CITY OF ALBUQUERQUE

May 26, 2015

Re: Juan tabo Hills Estates Onsite Drainage Analysis Report and Grading Plan Engineer's Stamp Date Report 8/20/14 and Grading Plan 2-24-15 and later submittal showing floodplains and floodway-no stamp- (M21D018)

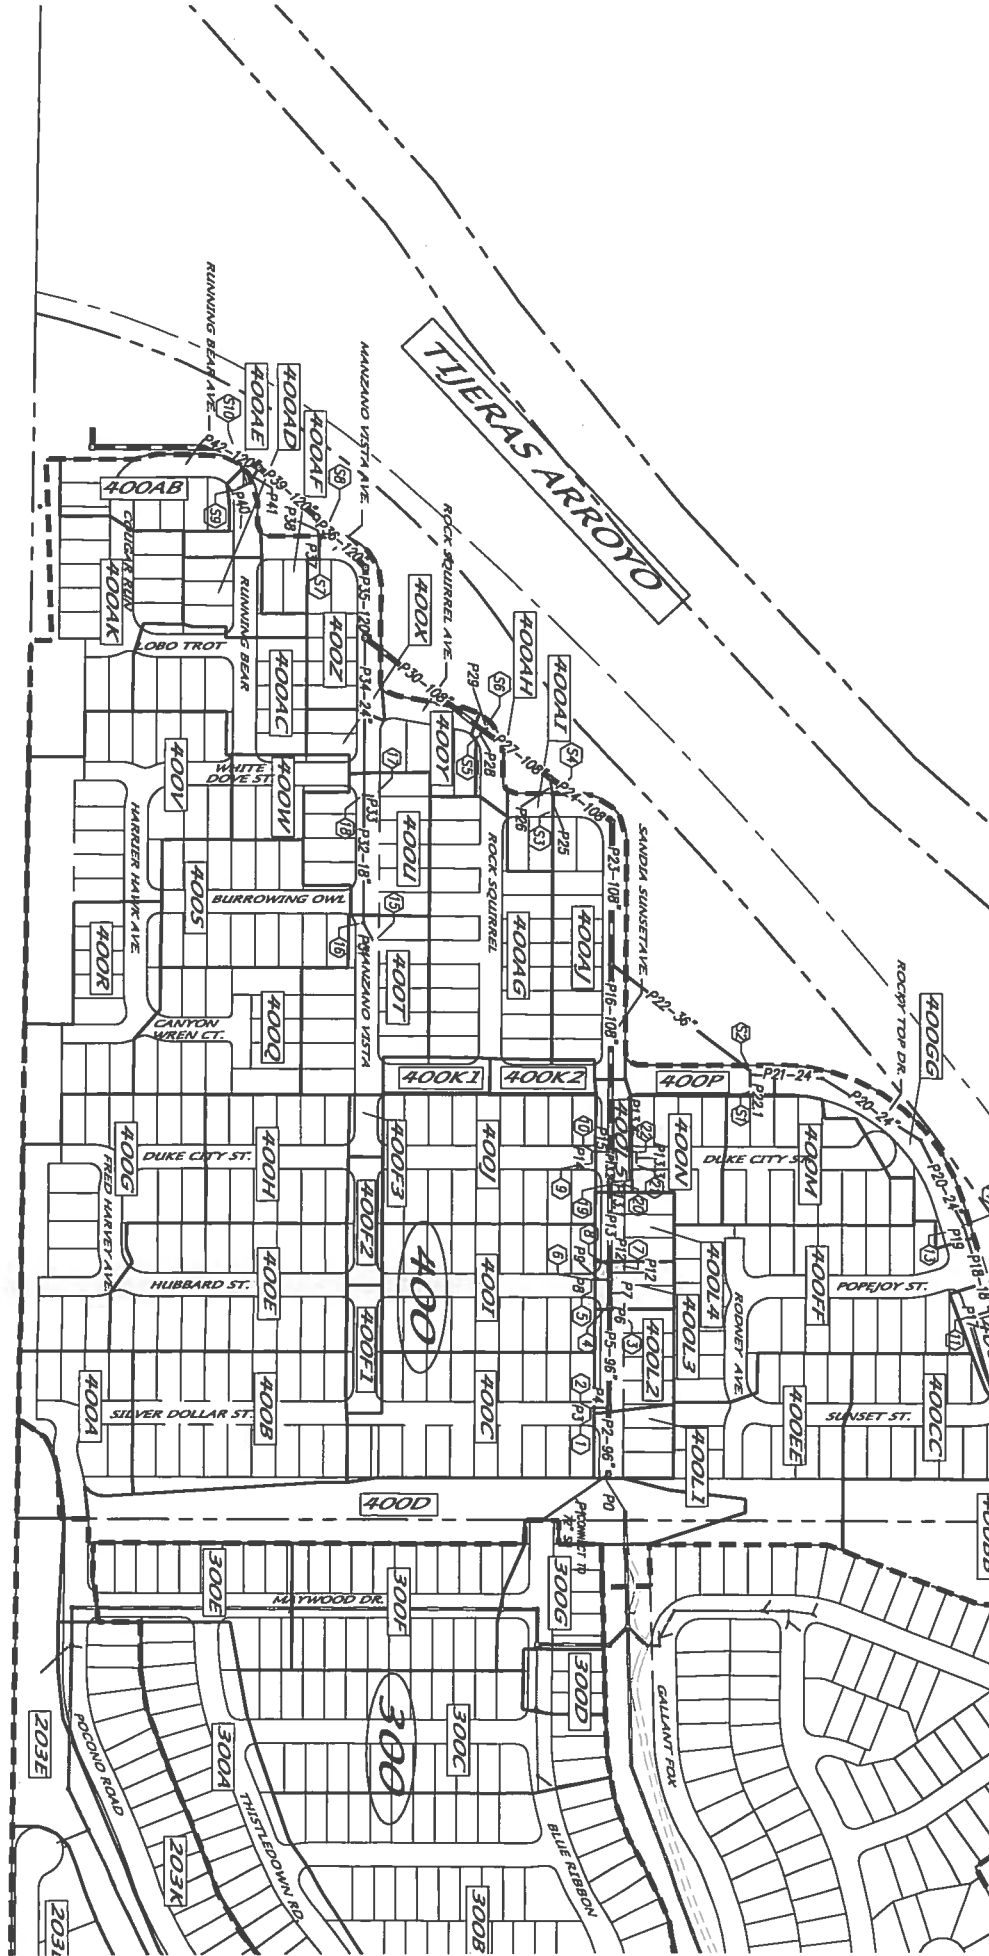
34. Adding the flows from Basins 400A, 400B and 400C the total is about 33 cfs, wherein the Summary Table shows 27.4 cfs.
35. The bypass for Basin 400B should be 21 cfs not 30 cfs.

36. Why does basin 400BB produce 9.4 cfs? There isn't any impervious area.
37. The bypass at basin 400 DD is 21.4 cfs. When added to the flows from basin 400 FF equals 39 cfs. Inlets 13 and 14 each accept 8 cfs (16 total). This leaves 23 cfs bypass. Zero bypass is shown in the table.

38. It is not obvious that values in the Hydrology Summary Table have been adequately reviewed so the City's review was terminated. Thoroughly review the Hydrology Summary Table and provide additional inlets and adequate storm drains where required.

**GRADING & DRAINAGE PLAN**

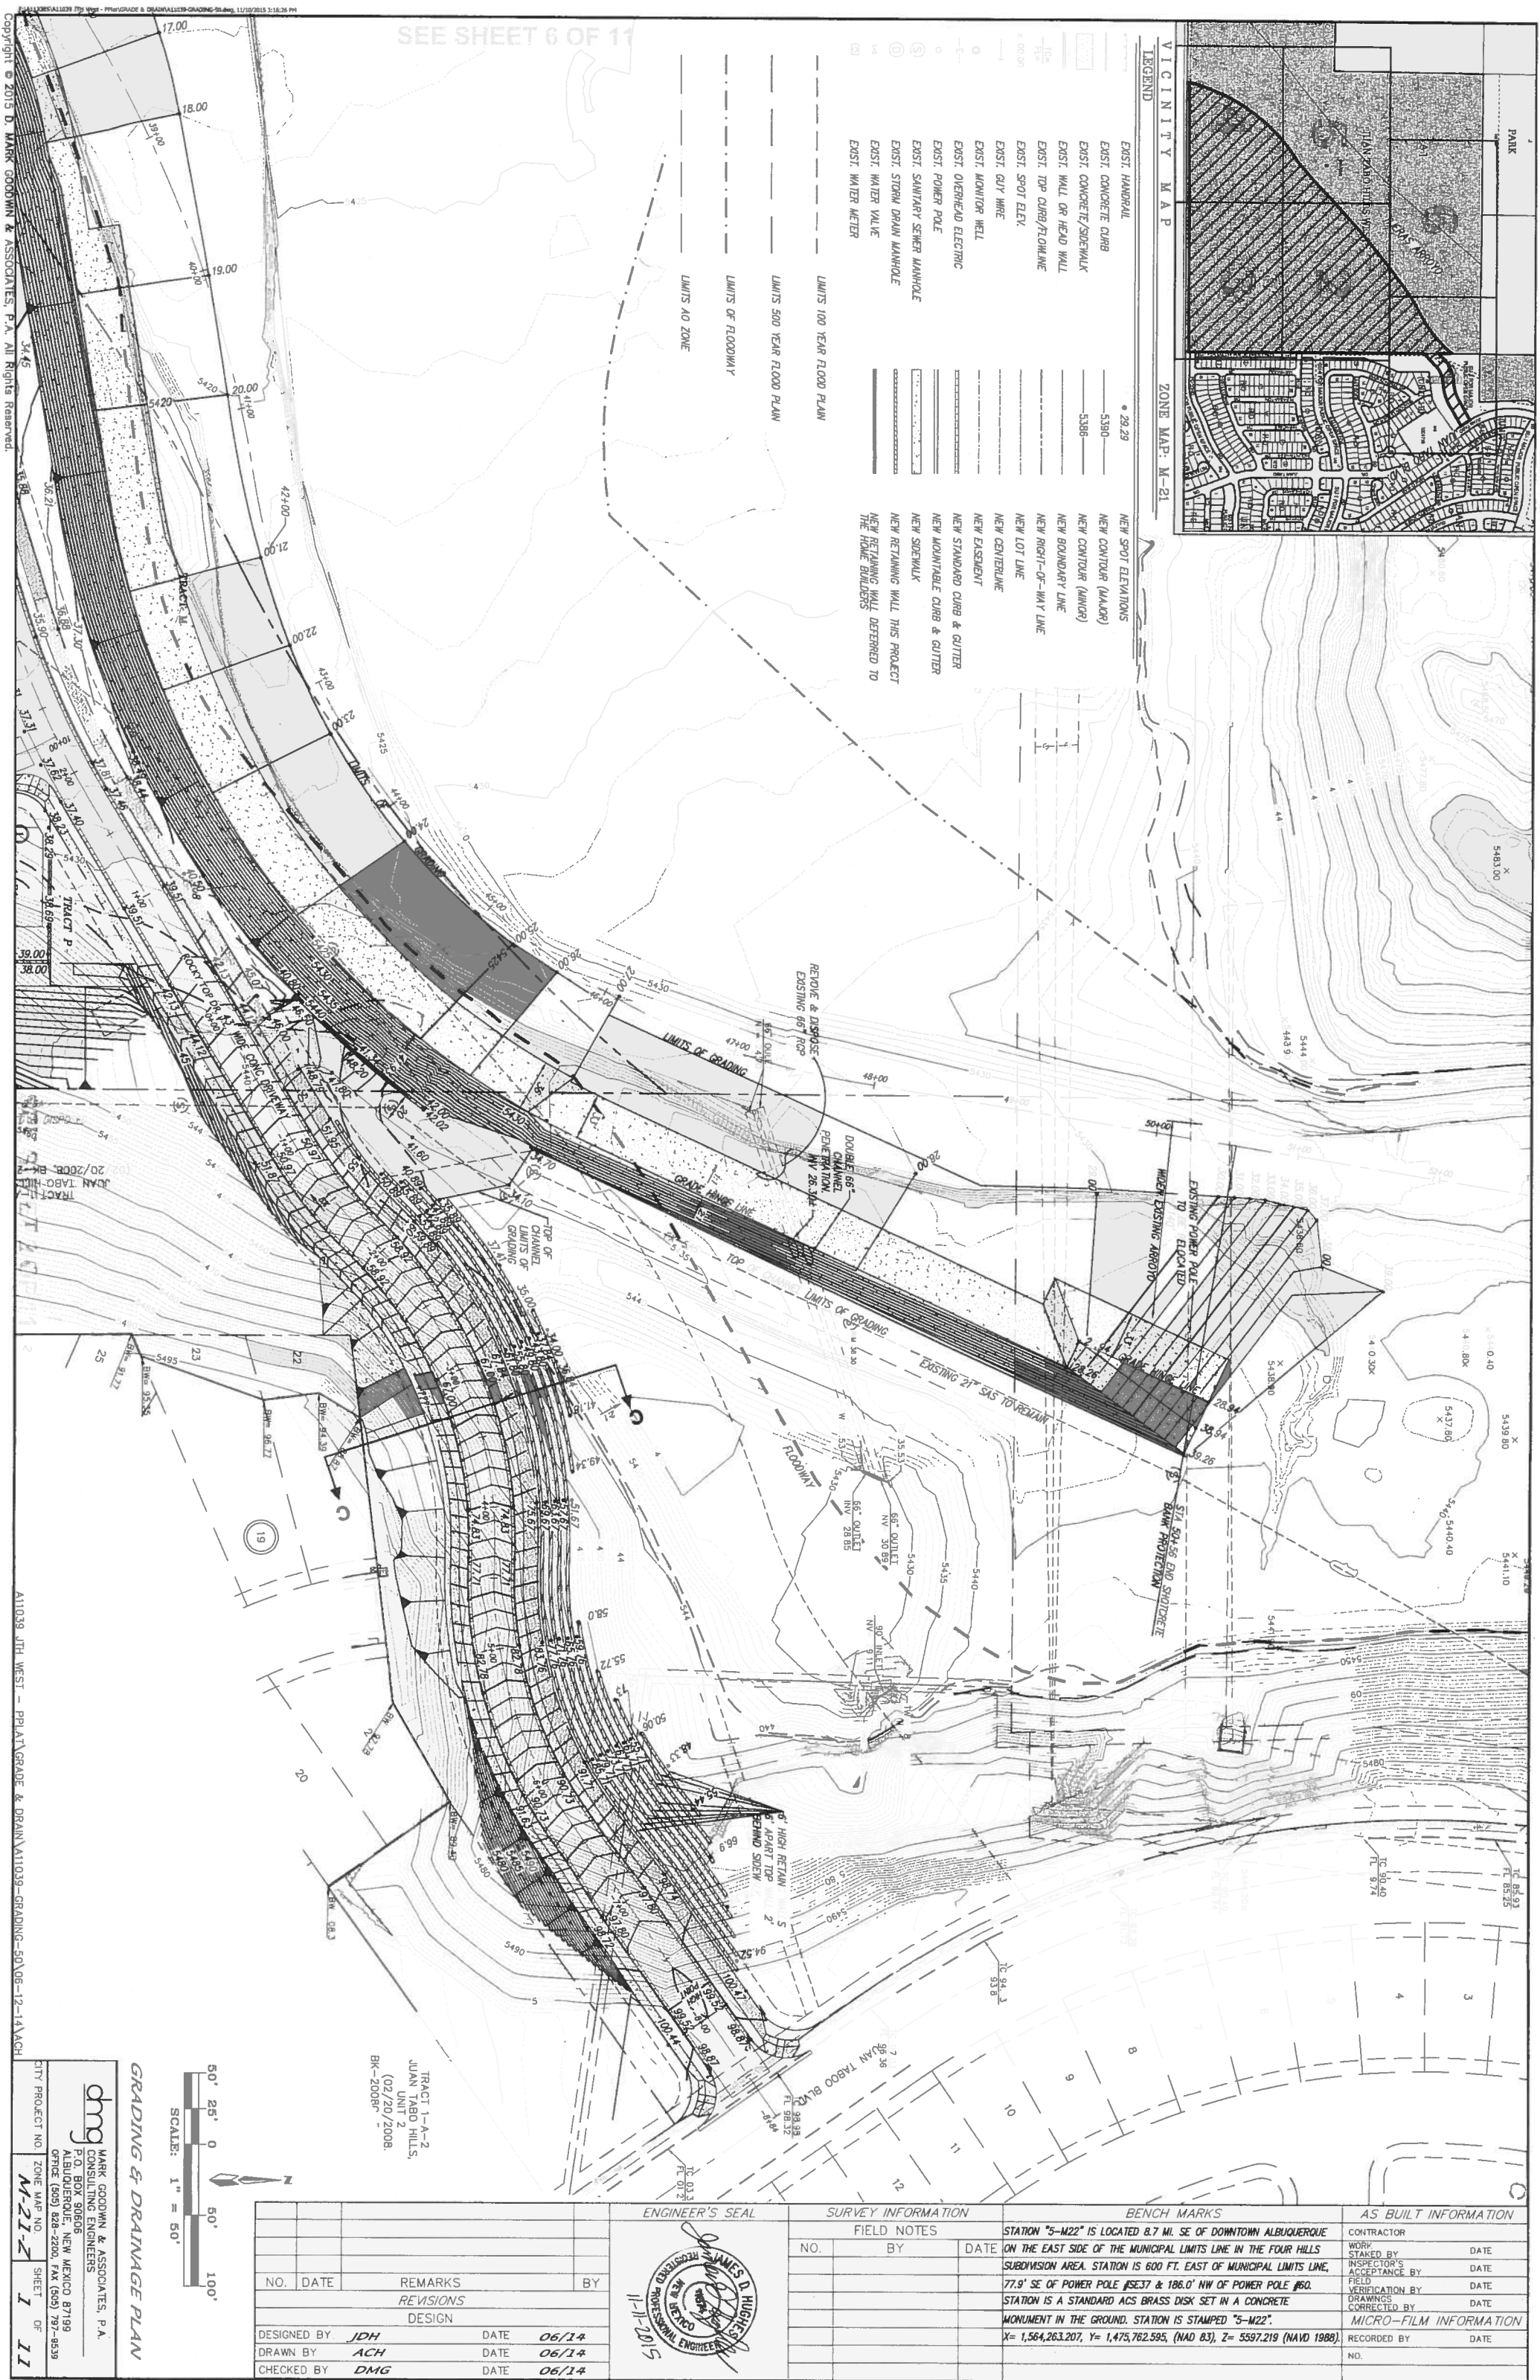
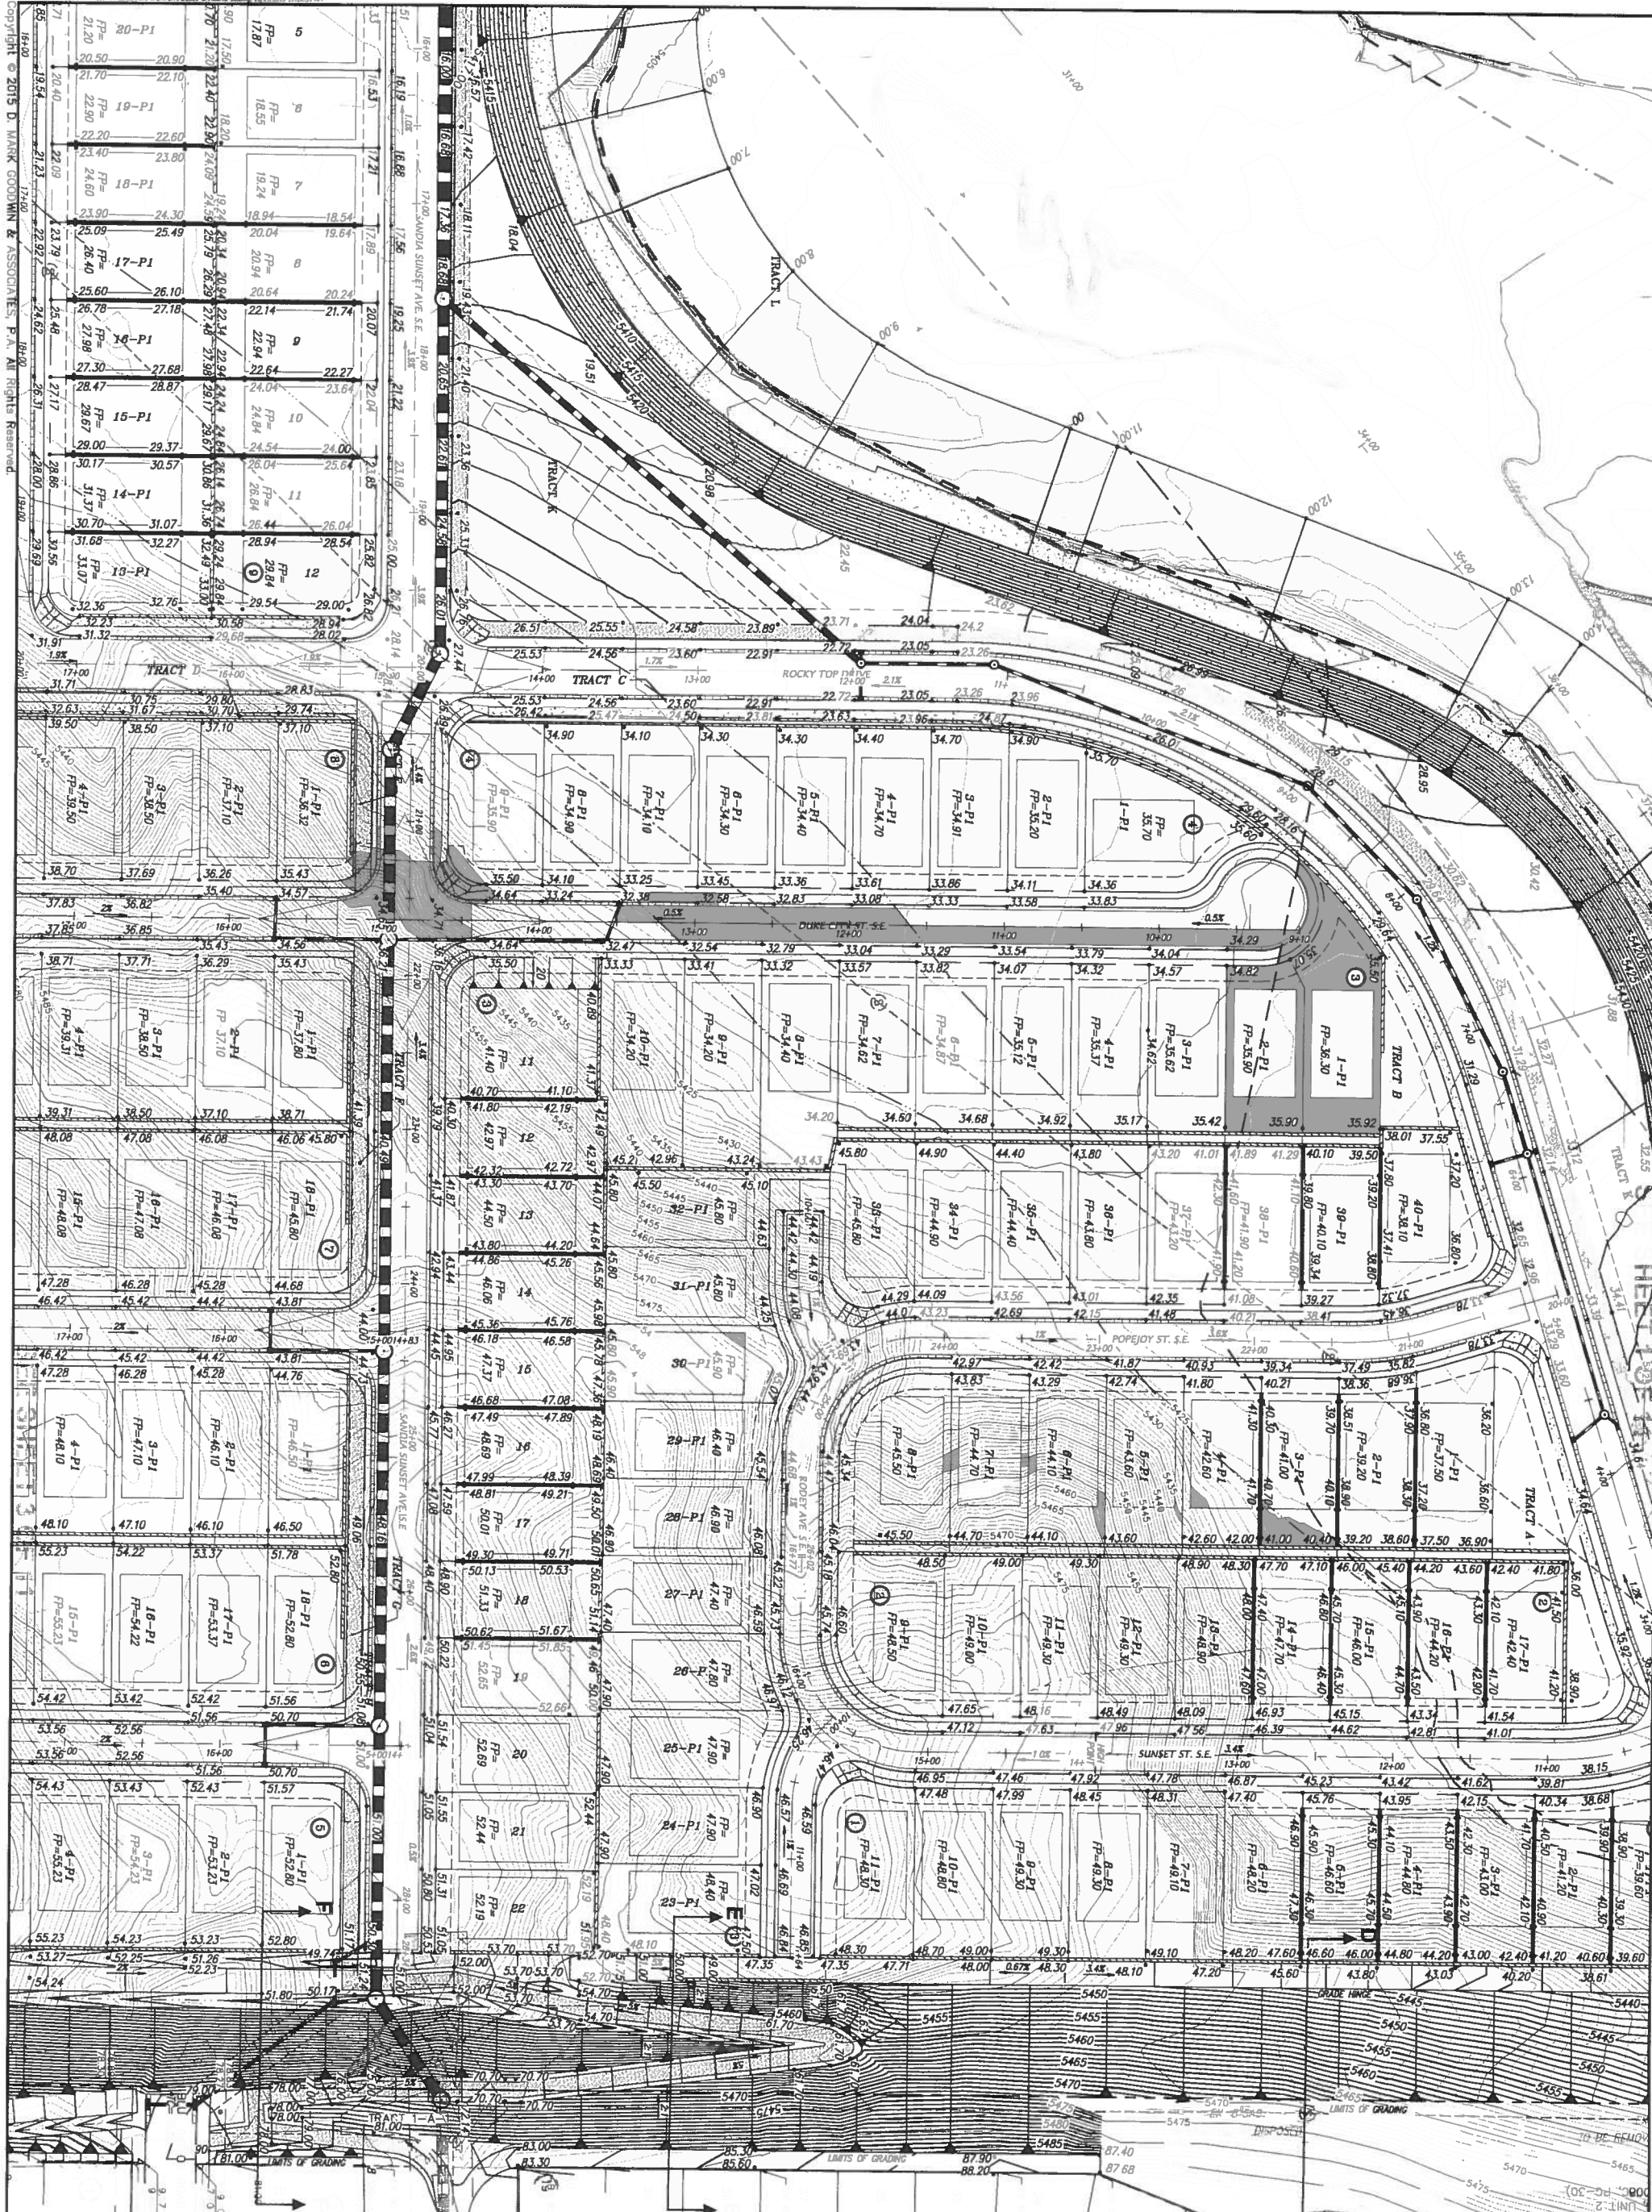
6. The grading plan was referred to regularly during the walk up the arroyo last week. It was difficult to follow the grading from Sheet 1 to Sheet 4 and back.

It is also not clear if pieces are missing upstream of Sheet 4. Provide a more continuous view of the grading next to the arroyo.

9. Provide FIS cross-section AM through AP on the grading plan. It was difficult to verify elevations and WSE between the grading plan and the FIS.
10. On Sheet 1, the Typical Lot layout and the "See Sheet 4 of 8" details obscure important parts of the grading plan. The existing and proposed grades are to be evident in this area and possibly further north depending on the response to comment 2 above.

14. Provide proposed spot elevations at the toe of the slope at the water quality pond (Sheet 1).
15. Provide proposed spot elevations at the slope toe (some locations there are two and three slope toes) along the eastern boundary.
